Engineers Comments Regarding Surface Water Drainage

Application Reference:	BR/67/25/PL	Reviewer Reference:	ADC/SB
Planning Officer:	Amber Willard	Date of Review:	19/08/2025
Site Name:	57 Queensway Bognor Regis PO21 1QN		
Application Description:	Demolition of existing brick-built garages, removal of canopy structure, remediation of contaminated land and construction of 18 No. flats over 3 storeys with pitched roofs. This application is in CIL Zone 4 (Zero Rated) as flats.		
Assessment Number:	1 of 1

Client:  
Project:  
57 Queensway, Bognor Regis, PO21 1QW  
Drawing:  
Proposed Drainage Strategy

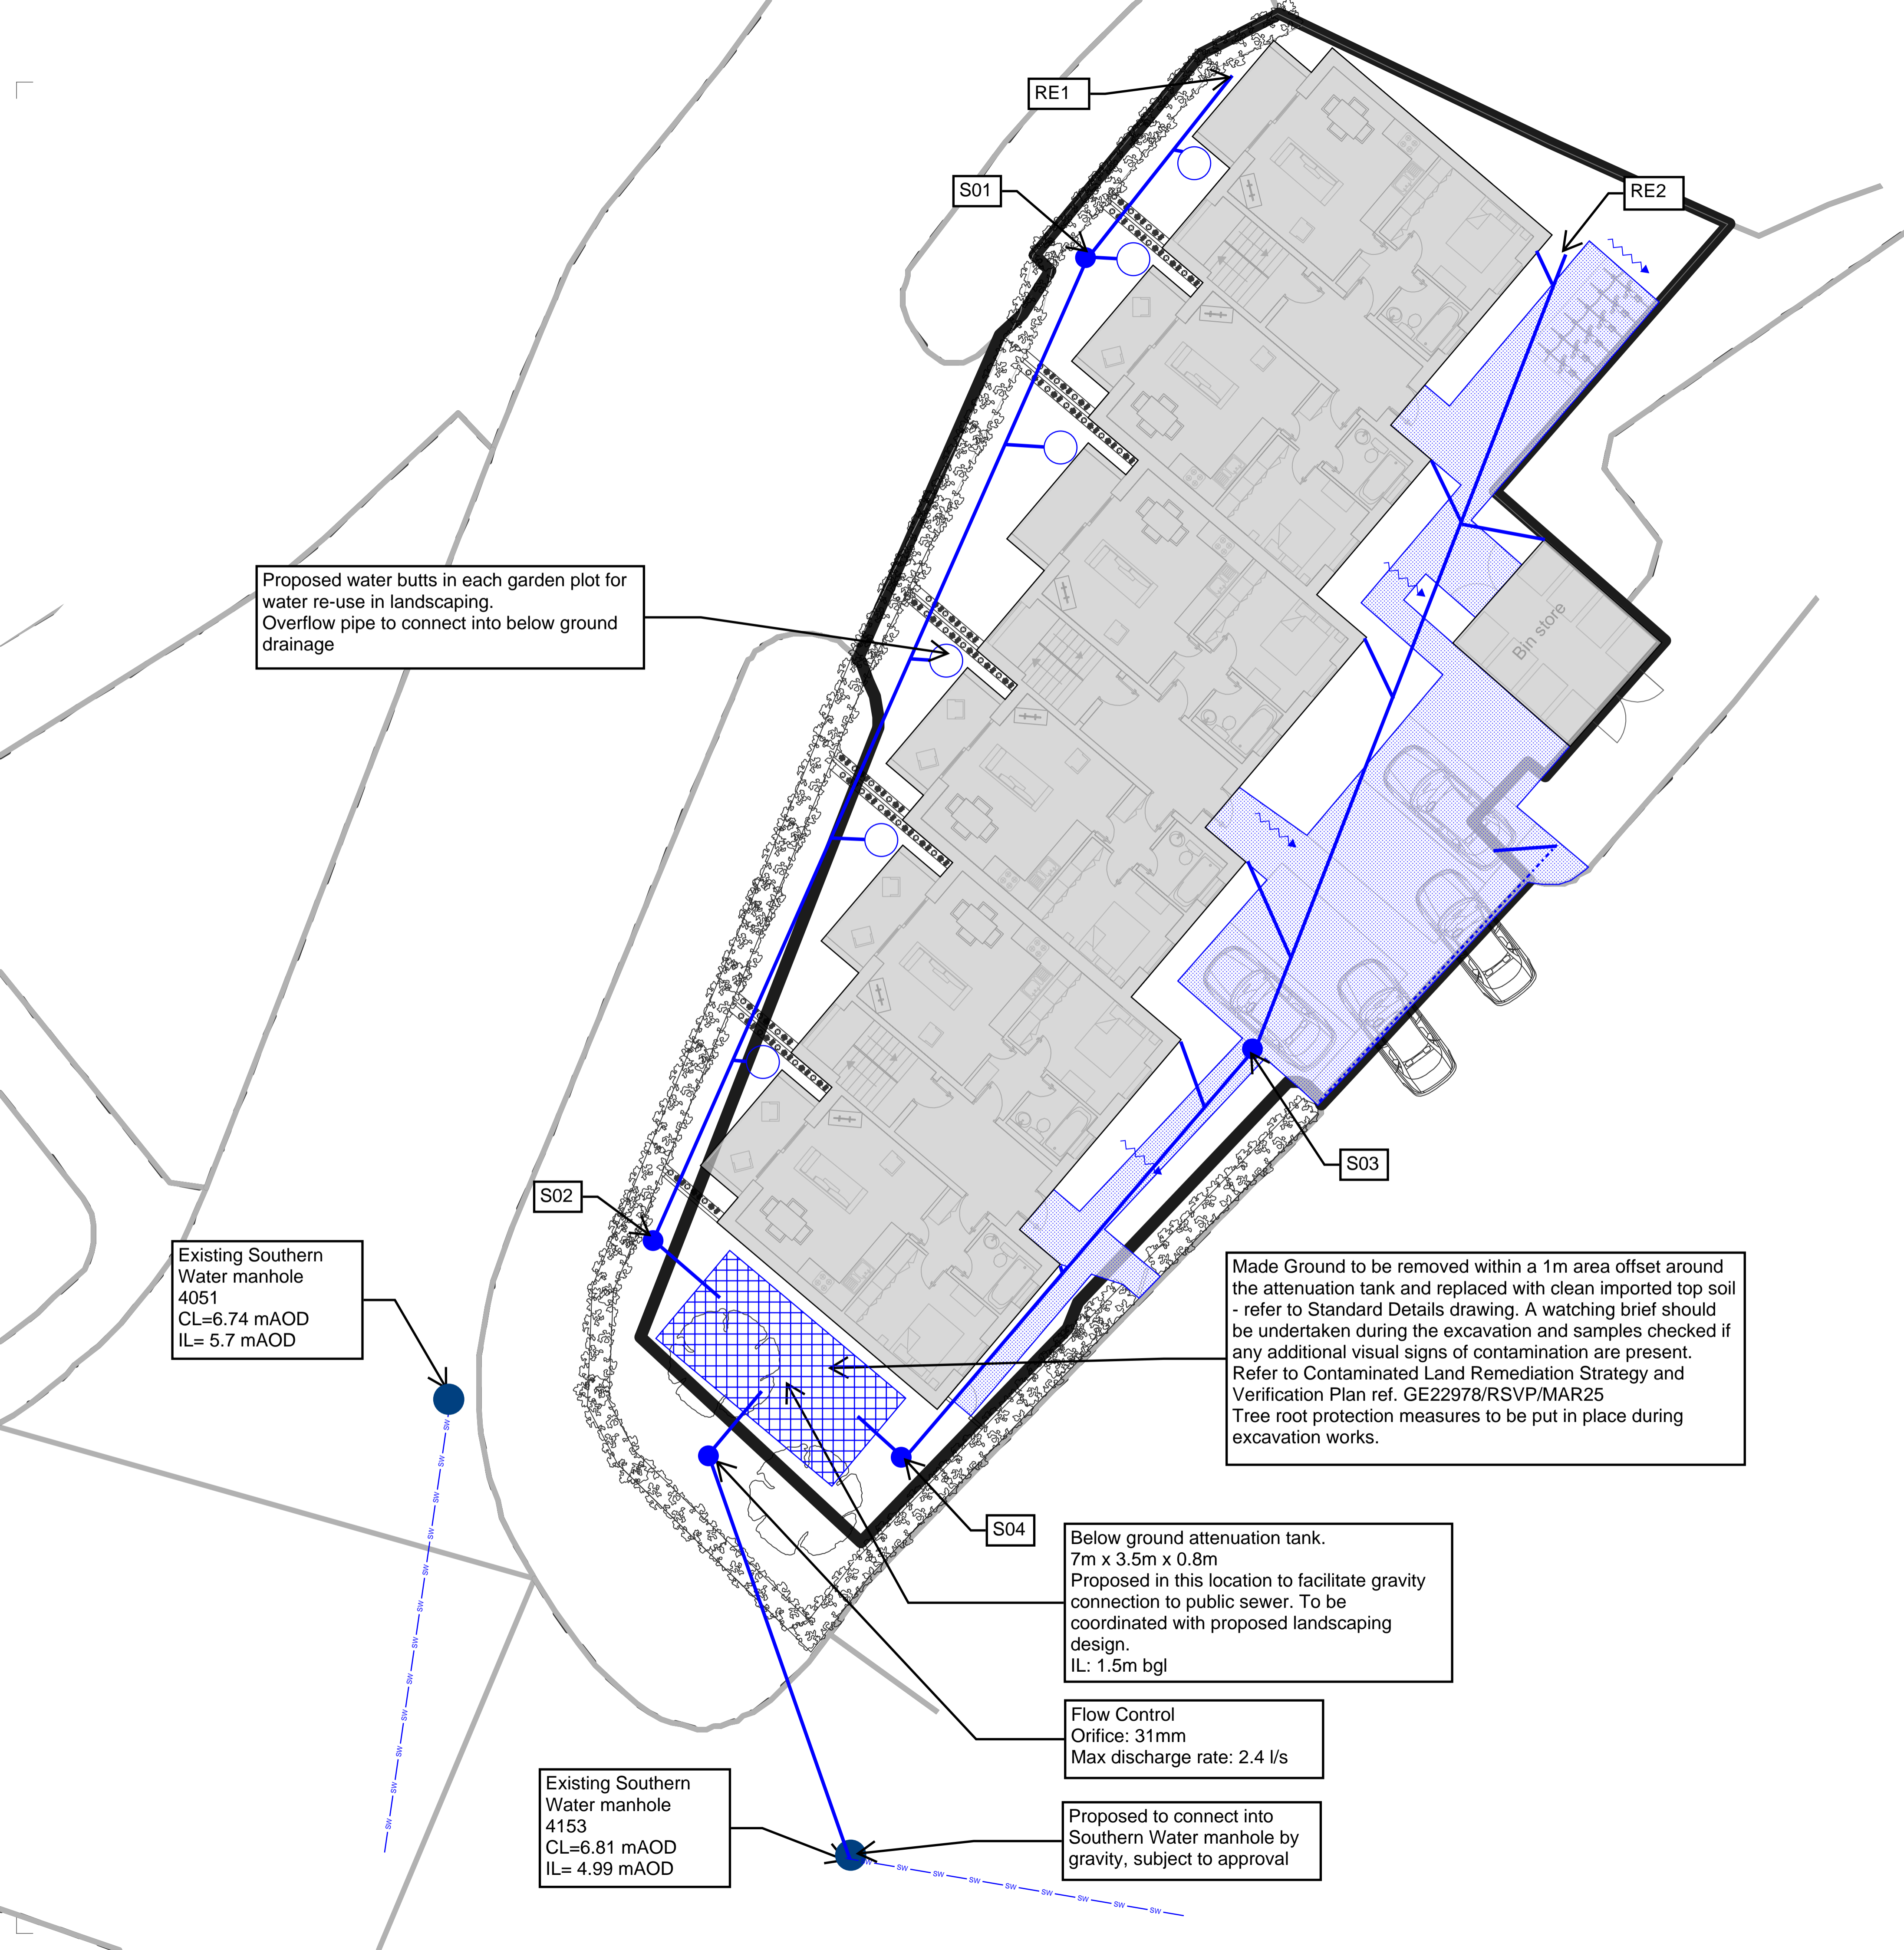
It is also not possible to corroborate the levels information that is in the model. There is no topographical survey, or proposed levels plan to demonstrate that the modelling is accurate. If cover levels are lower than those modelled, then this may mean that runoff floods the site when it is not designed to. The drainage layout lacks sufficient detail to enable comparison with the modelling beyond the tank and the flow control.

Most notably on the west side of the site where two trees are proposed directly over the attenuation tank for the site. Tree roots damage drainage infrastructure. Should groundwater levels be high, the tree roots damaging the liner of the tank could cause groundwater to consume storage that is reserved for surface water. This would increase flood risk in an extreme event if groundwater levels are high.

**Permeable Paving - Infiltration**

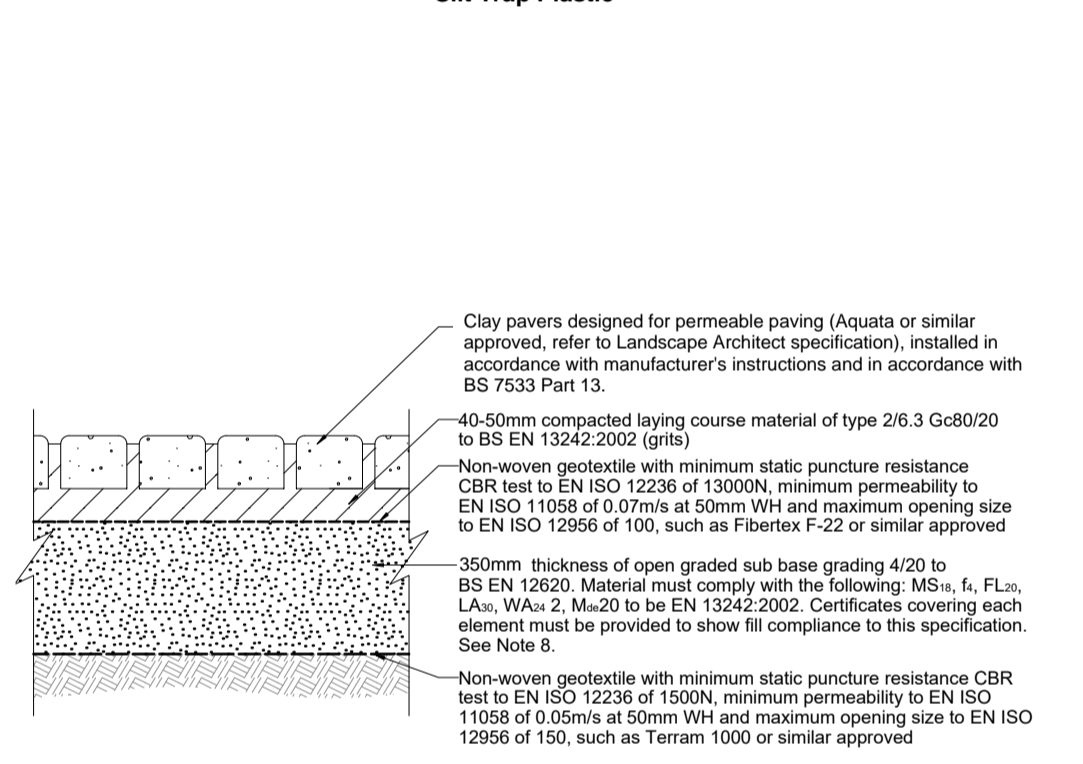
Despite infiltration being not being considered for the roof runoff, the designer has proposed 'self-draining' permeable surfacing for the access and driveways. This is not appropriate without ground investigations to support the approach. Groundwater may be high enough to enter the subbase, or the infiltration capacity of the soil may be so slow that there is insufficient capacity to drain subsequent events. If the equivalent area currently drains via a different method and infiltration is not viable then this proposal will increase flood risk.

**Rainwater Butt**

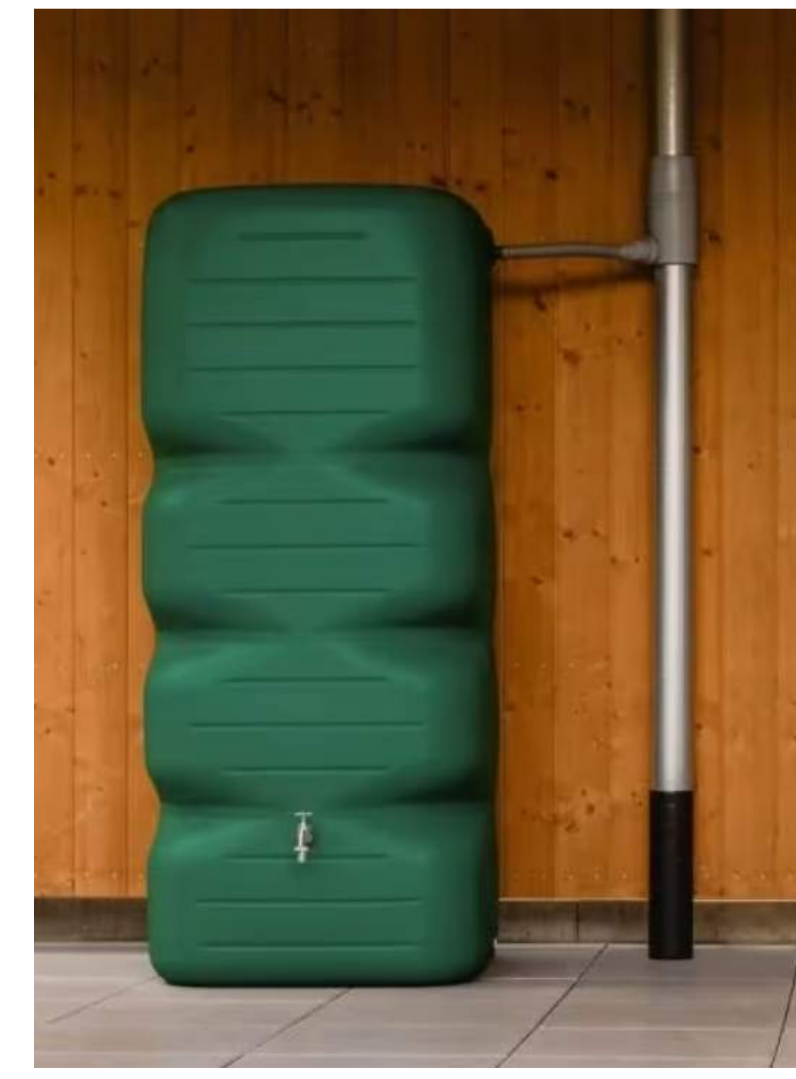
In the case of rainwater harvesting systems, these can be assumed to provide interception when they are “*designed for supply purposes (ie it has a regular daily demand)*”¹. The designer has proposed rainwater butts for water reuse, however, these do not appear to be designed for water supply purposes. It is assumed therefore that these will not provide adequate interception drainage as there is a risk that the water butts will not provide this function for the lifetime of the development (as they may not be used or emptied).
